Project: Anita Bolz
Subject: PV System Structural Compliance
Date: 1/17/2019

Model Energy, PLLC has reviewed the installation details of the proposed PV system that is to be installed by Emerald Energy at 66 Sherman Pines Drive, Fuquay-Varina, NC 27526. The review was limited to the structural elements involved in the construction and not the electrical, mechanical, etc.

5 ATTACHMENT LAYOUT

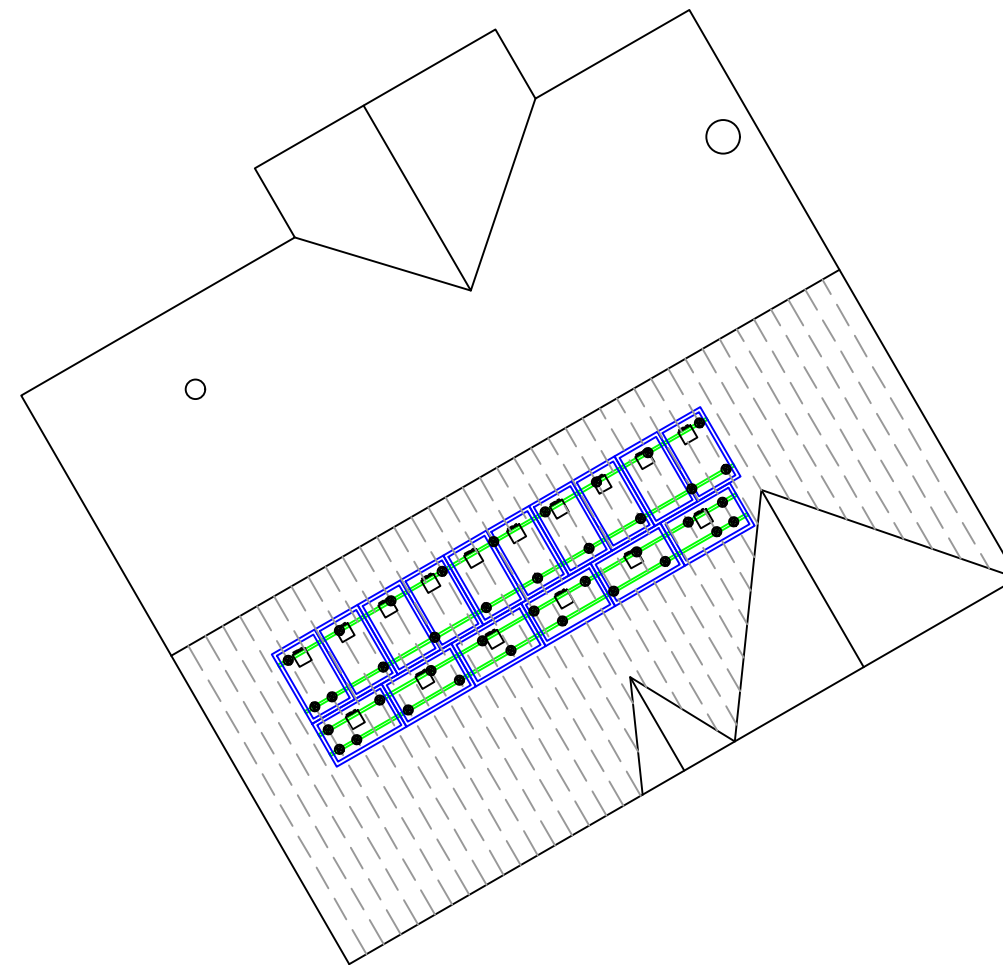
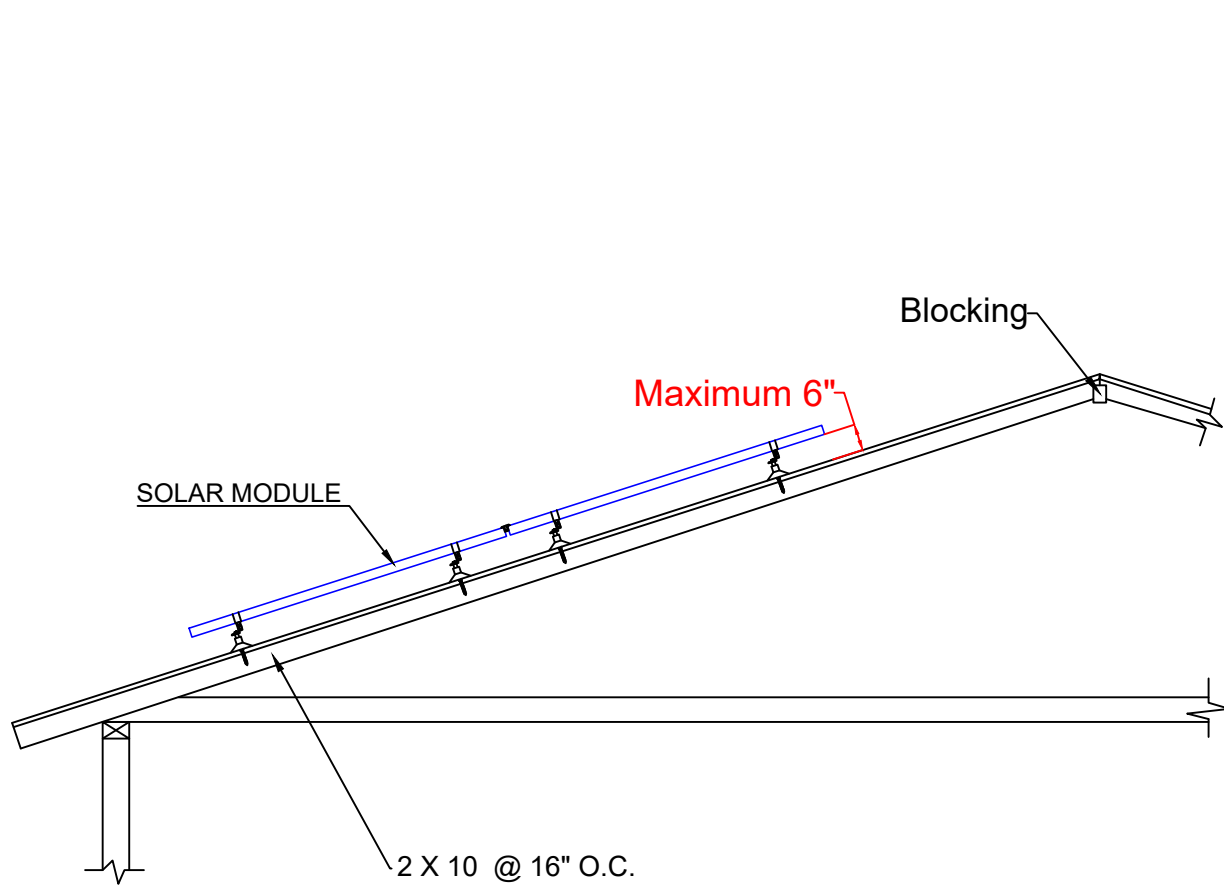
The existing roof structure is comprised of 2"x10" wood rafters spanning 19'-8" from hip to ridge. On top of this is 5/8" thick OSB roof sheathing, with tar paper, and a single layer of asphalt shingles. The estimated dead load of the existing materials is 3.9 psi (1.6 psi for sheathing + 2.3 psi for shingles). The existing structure has been sized and spaced for supporting a dead load up to 10.0 psi. The additional dead load of the PV system and the existing roof elements gives a total dead load of 6.6 psi which can be adequately supported by the existing roof structure.

Based on the wind loading method outlined in ASCE 7-05 and the conditions/materials used in this installation, the following roof attachment layout is required for properly securing the PV system to the roof structure:

1. The attachments on the end of each rail shall be within 12" of the end of the rail.
2. Interior attachments within 36" of a roof edge and peak or two roof edges, "Zone 3", may be spaced apart no more than 32".
3. Interior attachments within 36" of a roof edge or peak, "Zone 2", may be spaced apart no more than 48".
4. Interior attachments that are NOT within 36" of a roof edge or peak, "Zone 1", may be spaced apart no more than 64".
5. Staggering the attachments of the top and bottom rails is preferable, but not required.
6. A single 5/16" x 4.5" (2.5" thread) lag screw shall secure each attachment foot to a roof member. Follow the manufacturers recommended pilot hole size to ensure proper fastening.
